**Re: Sundance Construction Beverly Hills
Erosion and Sediment Control Plan
Engineer's Stamp Date 2-26-18 (B18E023)**

Based upon the information provided in your submittal received 3-2-18, the above referenced plan is not approved until the following comments are addressed:

C-103

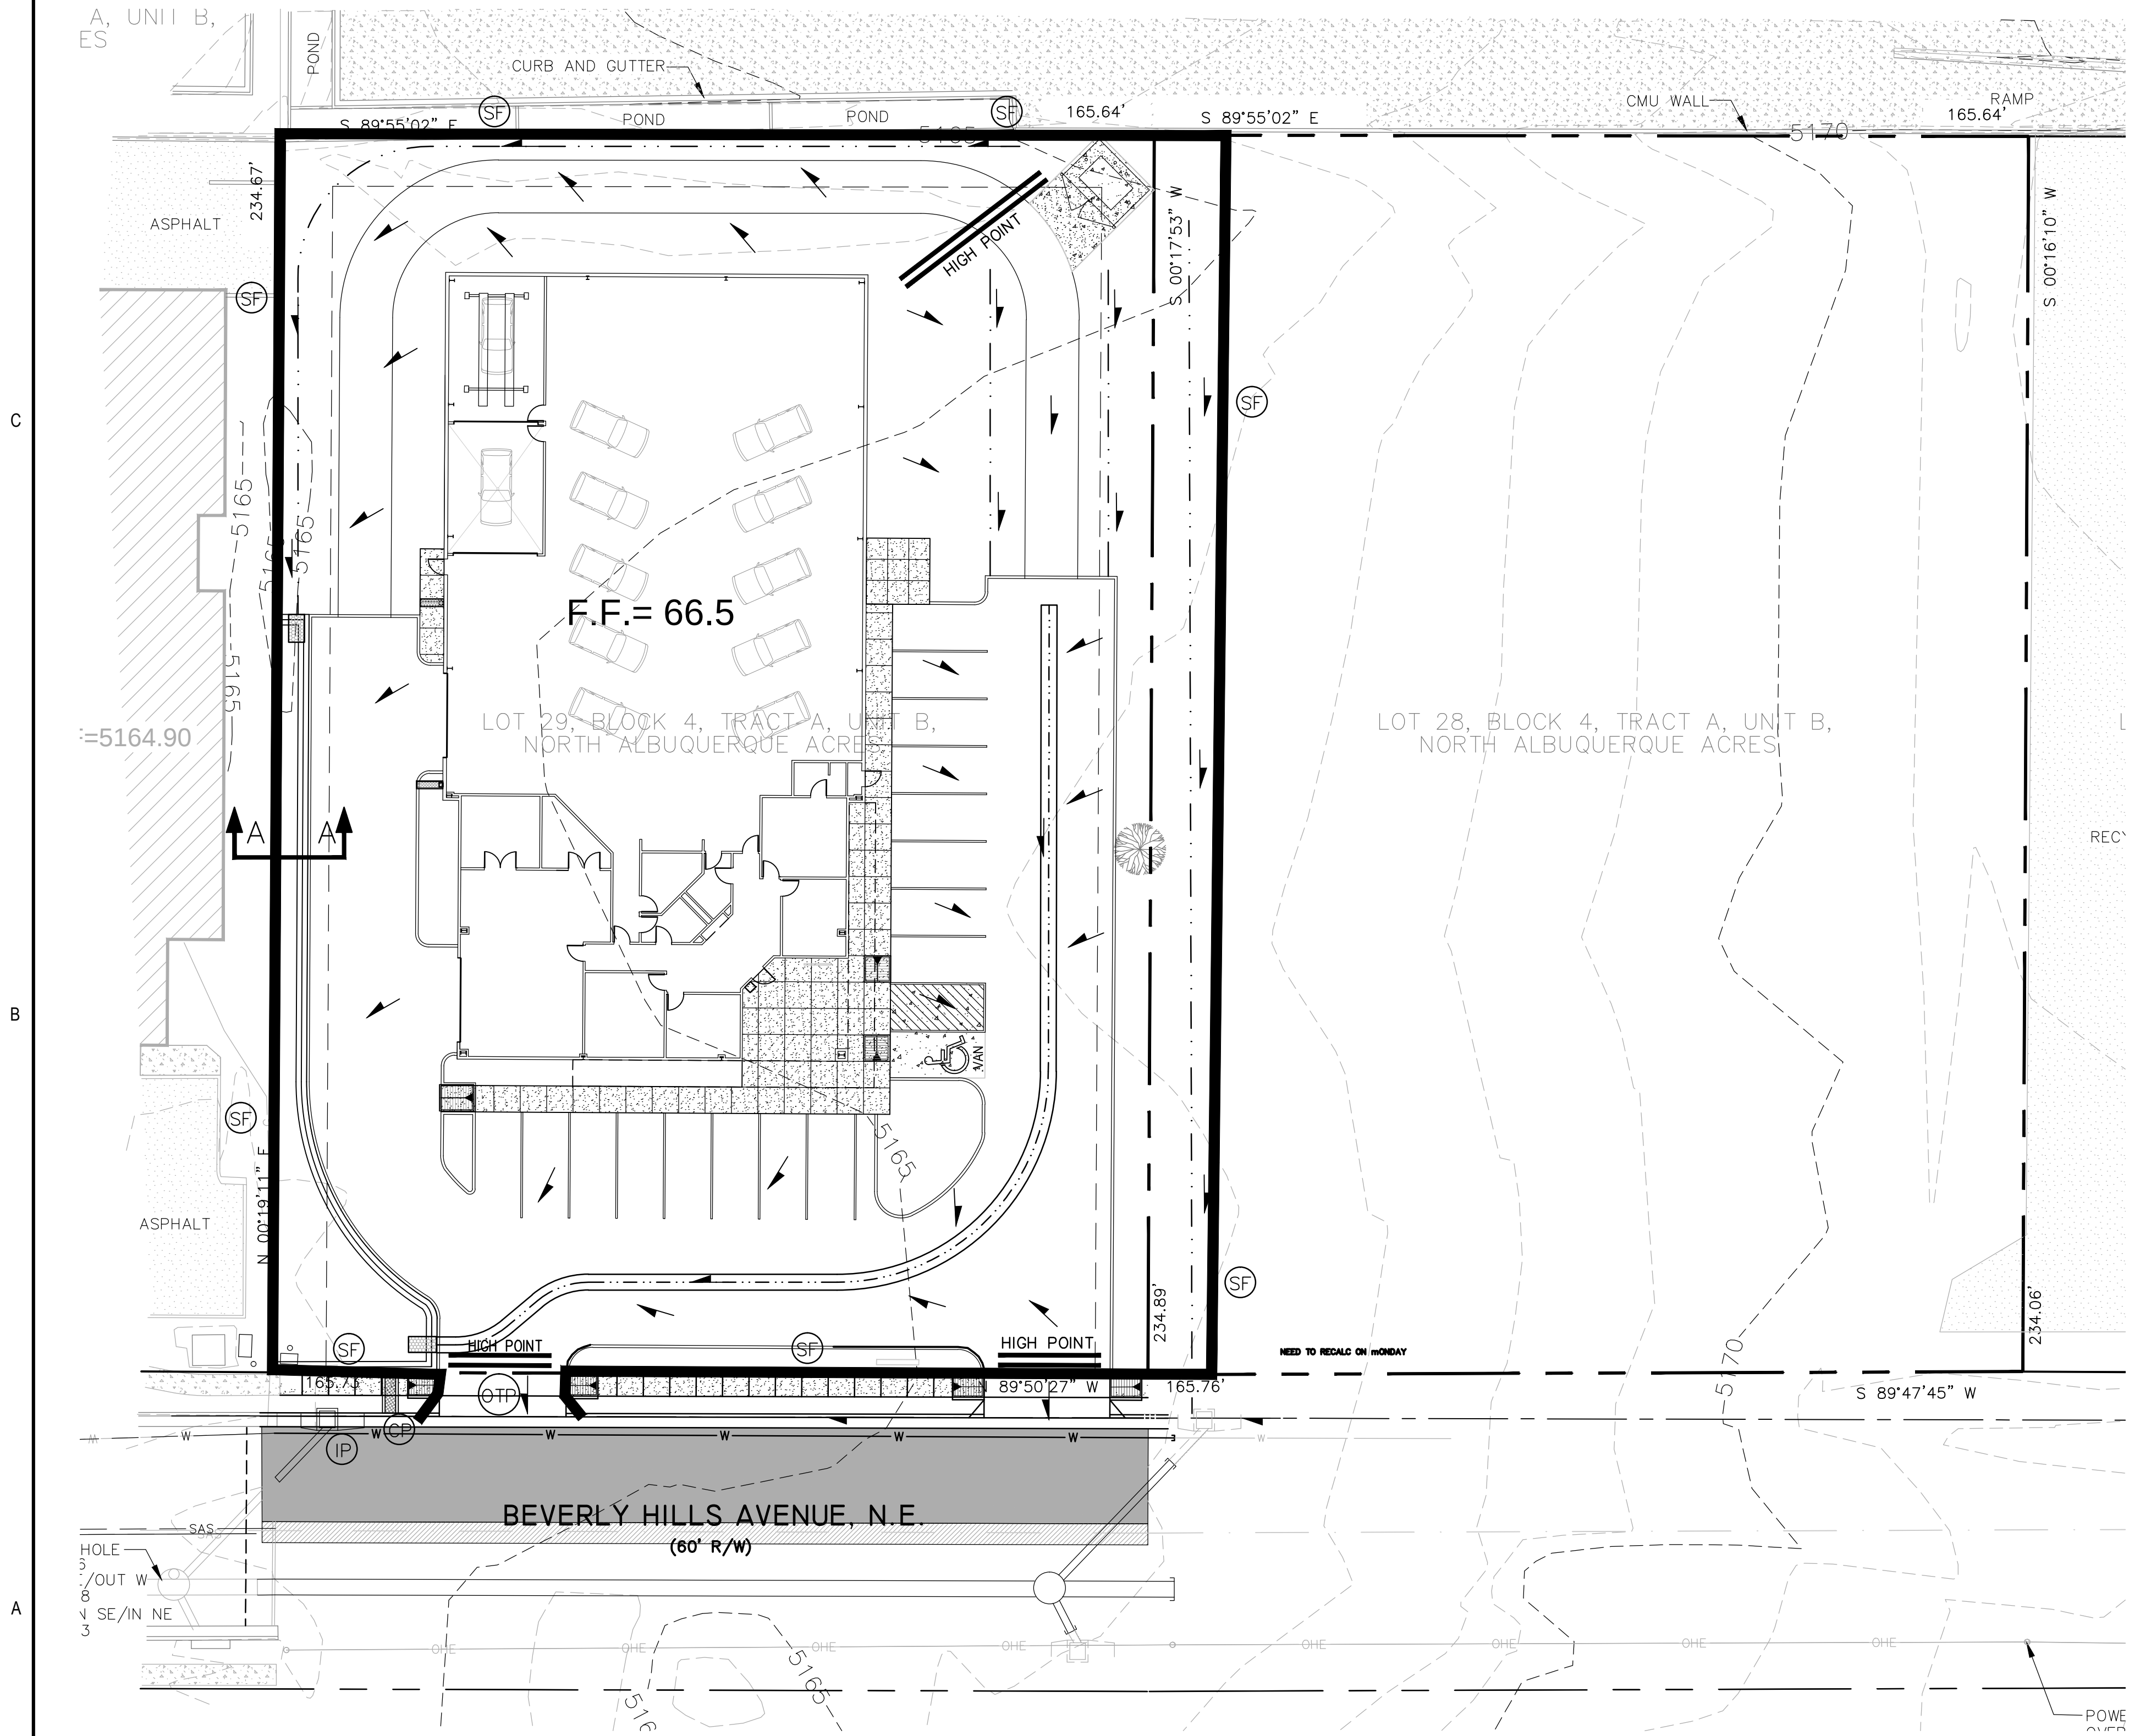
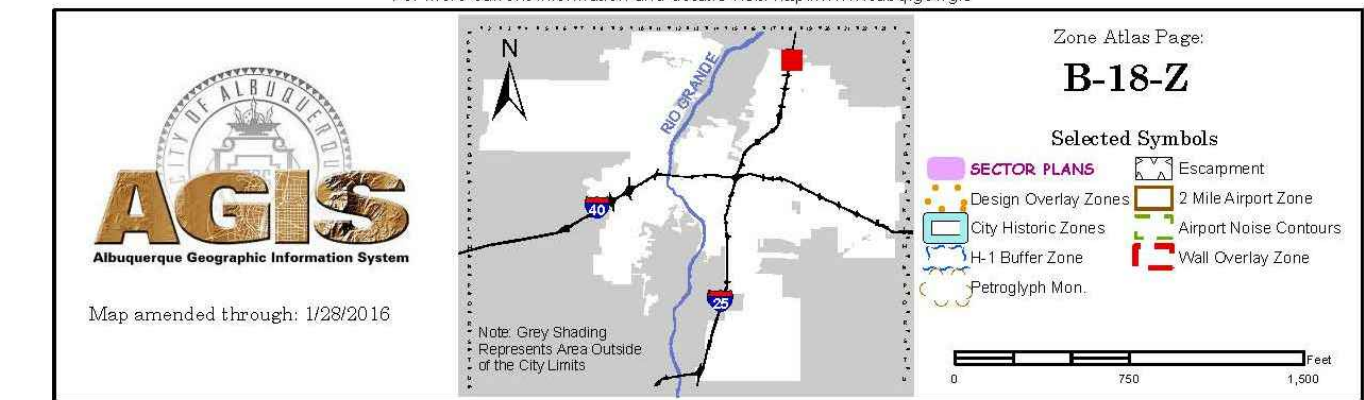
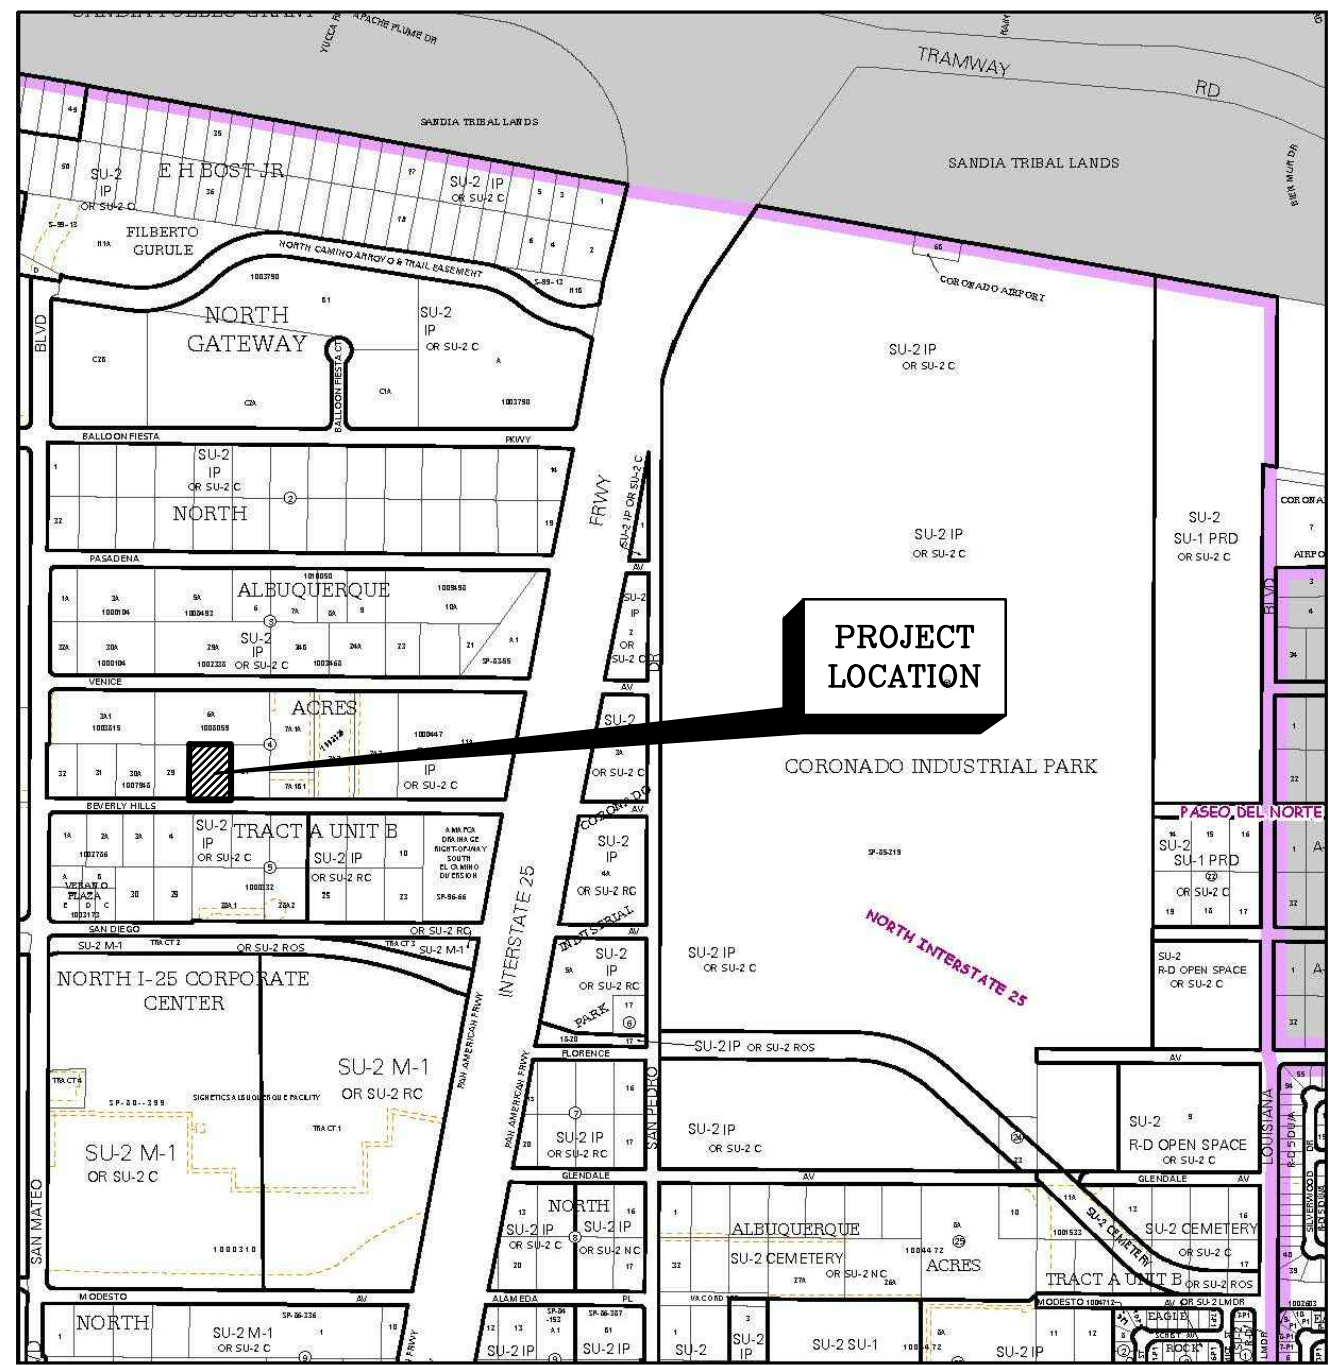
1. The Erosion and Sediment control plan is to have grades and show drainage features. The best way to accomplish this is to show BMPs on the grading and drainage plan.

2. Propose inlet protection for the inlet on the south side of Beverly Hills Ave located just west of the edge of pavement.

3. Propose a sediment BMP (e.g mulch sock) in the gutter west of the edge of pavement on the north side of Beverly Hills Ave and in the gutter on the south side of Beverly Hills Ave just west of the inlet.

4. The culvert protection should be located on the upstream side of the sidewalk culvert if needed. If the pond in the southwest corner is deep enough (depth > 2 feet), it may not be required.
